Rezoning Transportation Analysis

Petition Number: 2022-176

RZ1.00

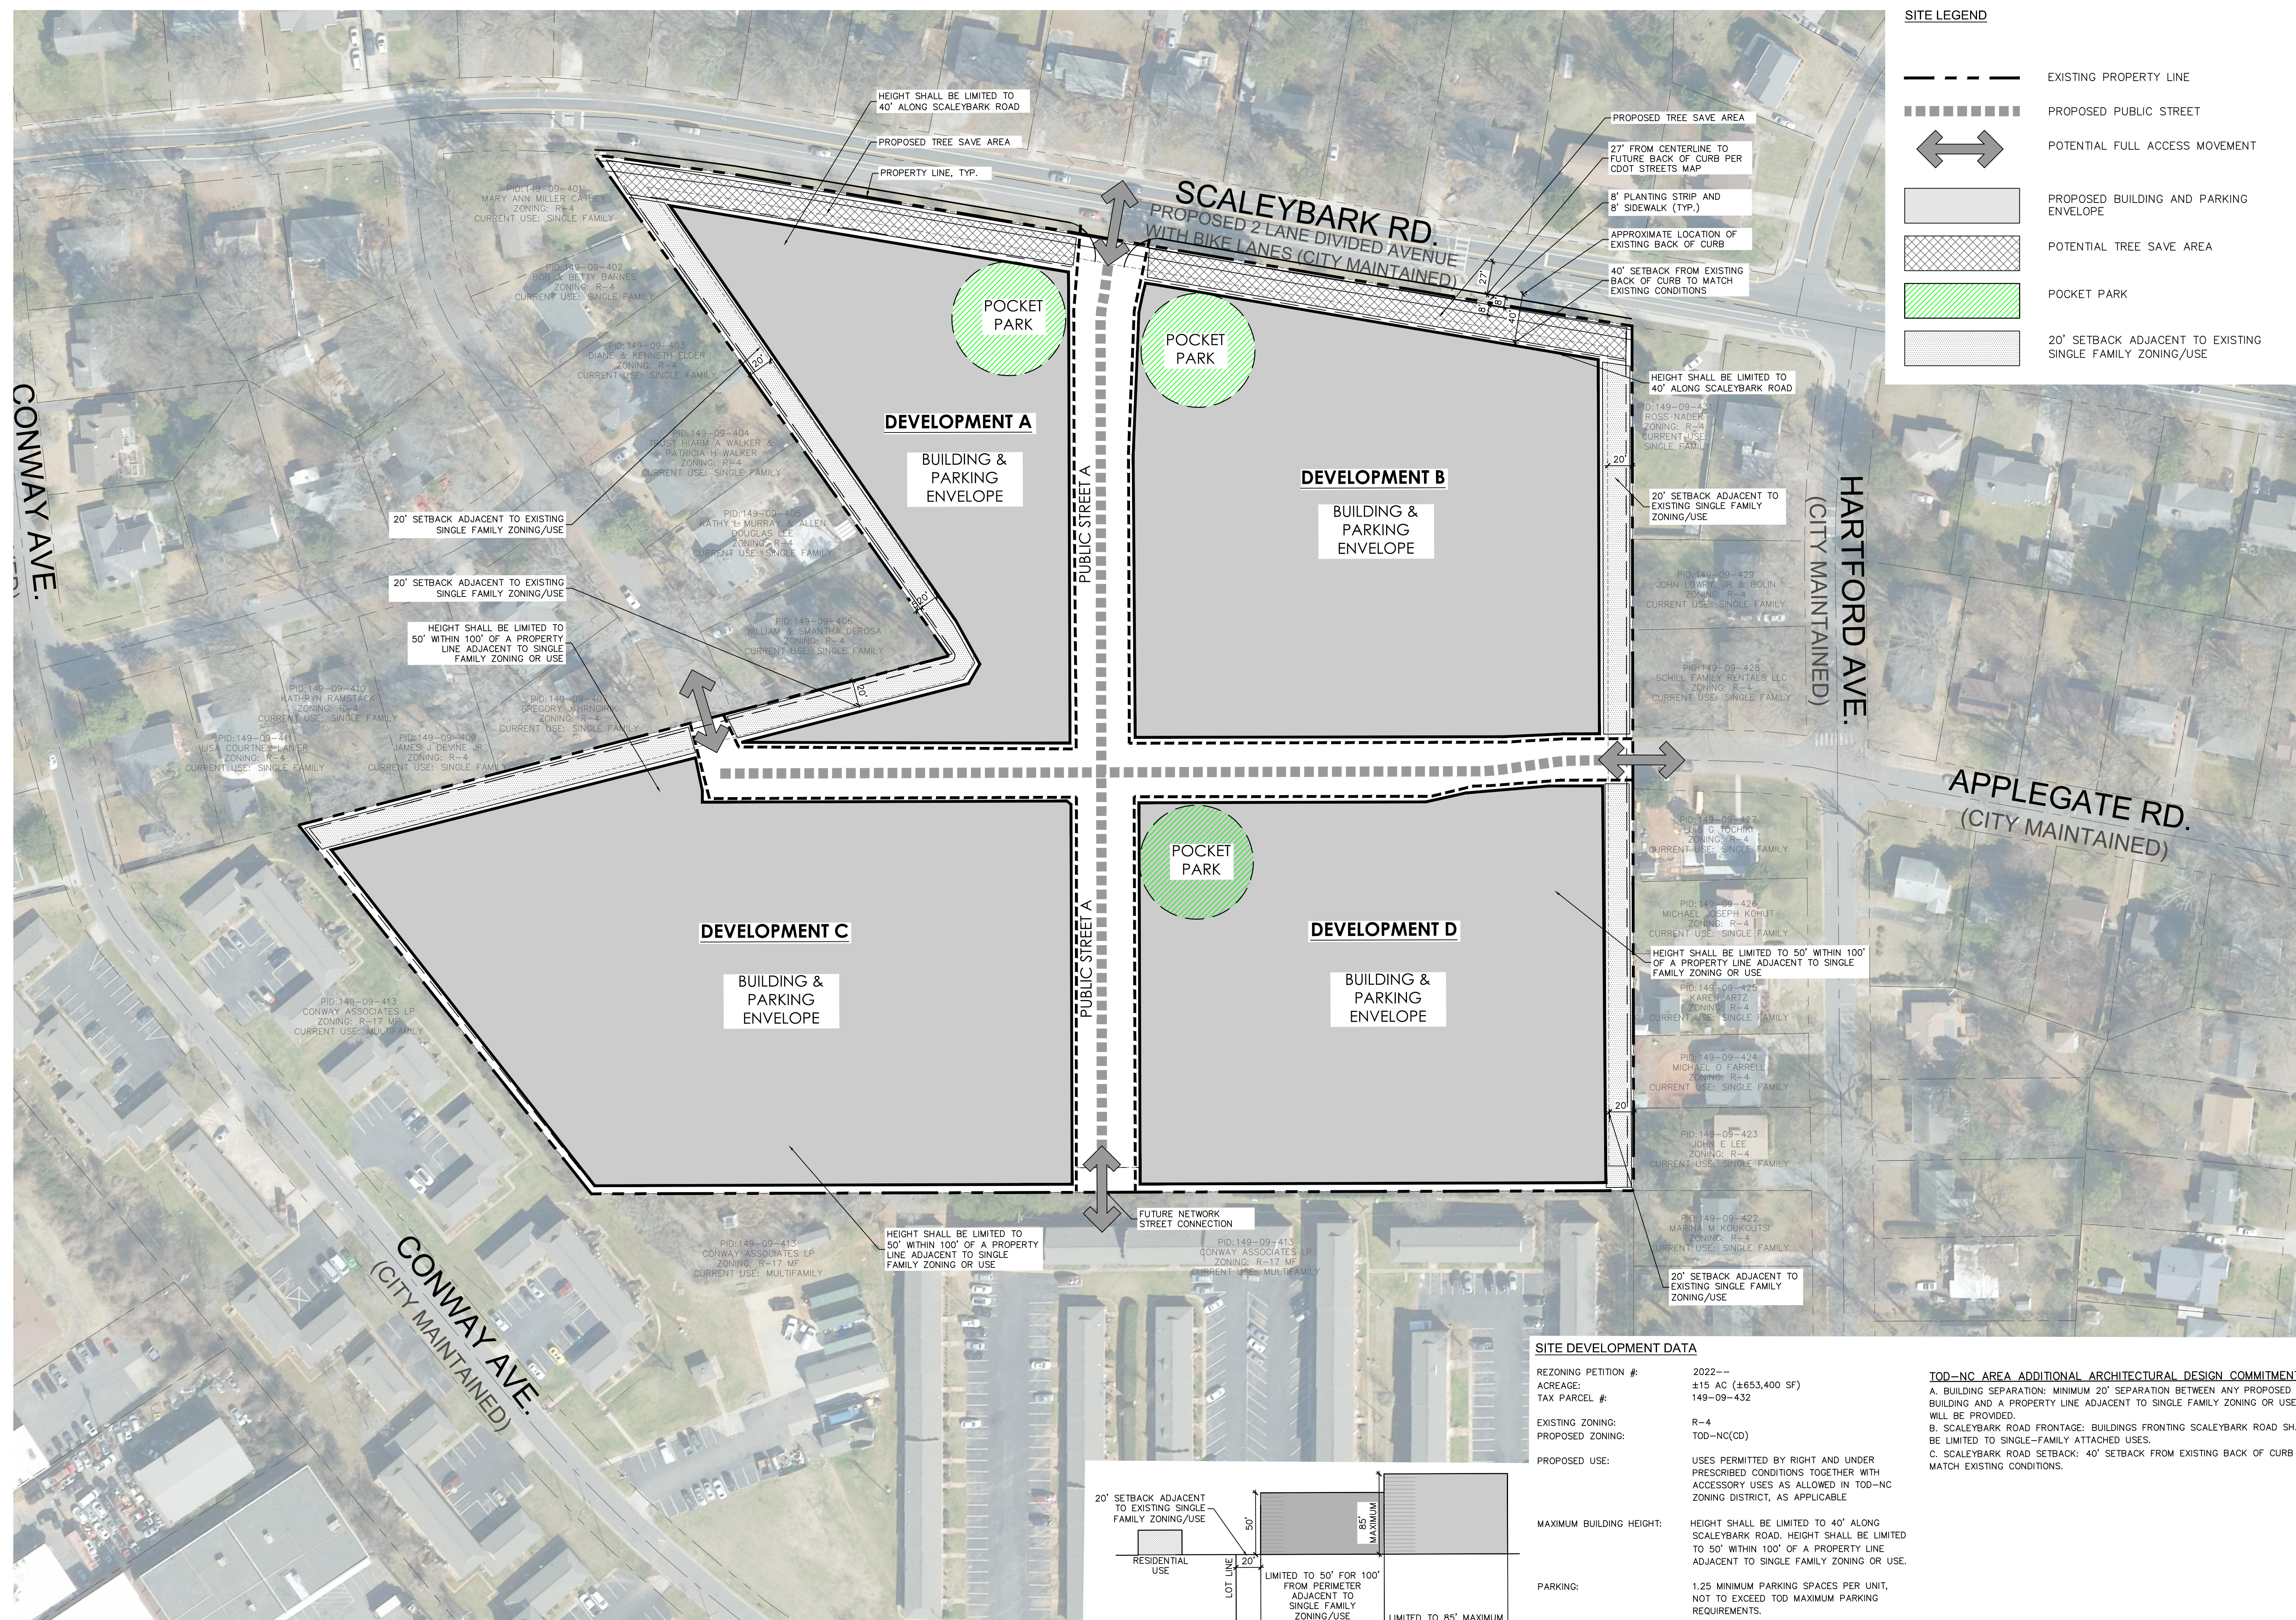
- a. **Scaleybark Road:** Location of the future curb and gutter is located 27 feet from roadway centerline to accommodate the Charlotte Streets Map with a roadway typical section of a two-plus avenue with buffered bike lanes. The existing curb line is not required to be relocated with this petition.

Label and dimension the curb and gutter from the centerline for each road on the site plan.

3. Revise site plan and conditional notes to specify the proposed land uses and densities for the petition.
4. Revise site plan and conditional notes to show the horizontal street as a public street. In addition, provide CDLSM design standards for all proposed roads.

5. Revise site plan and conditional notes to commit to removing the existing school zone flashers and pavement markings. Include note that all signal equipment is to be returned to CDOT Operations Division. Further coordination is necessary to determine the plan for the existing HAWK signal in front of site once more information is provided on the land uses and densities.

6. Revise site plan and conditional note(s) to commit to dedicate 30-feet of right-of-way from the road centerline. The site plan shall label and dimension the right-of-way from the road centerline. If proposed sidewalk is outside of right-of-way provide additional right-of-way or provide sidewalk utility easement.
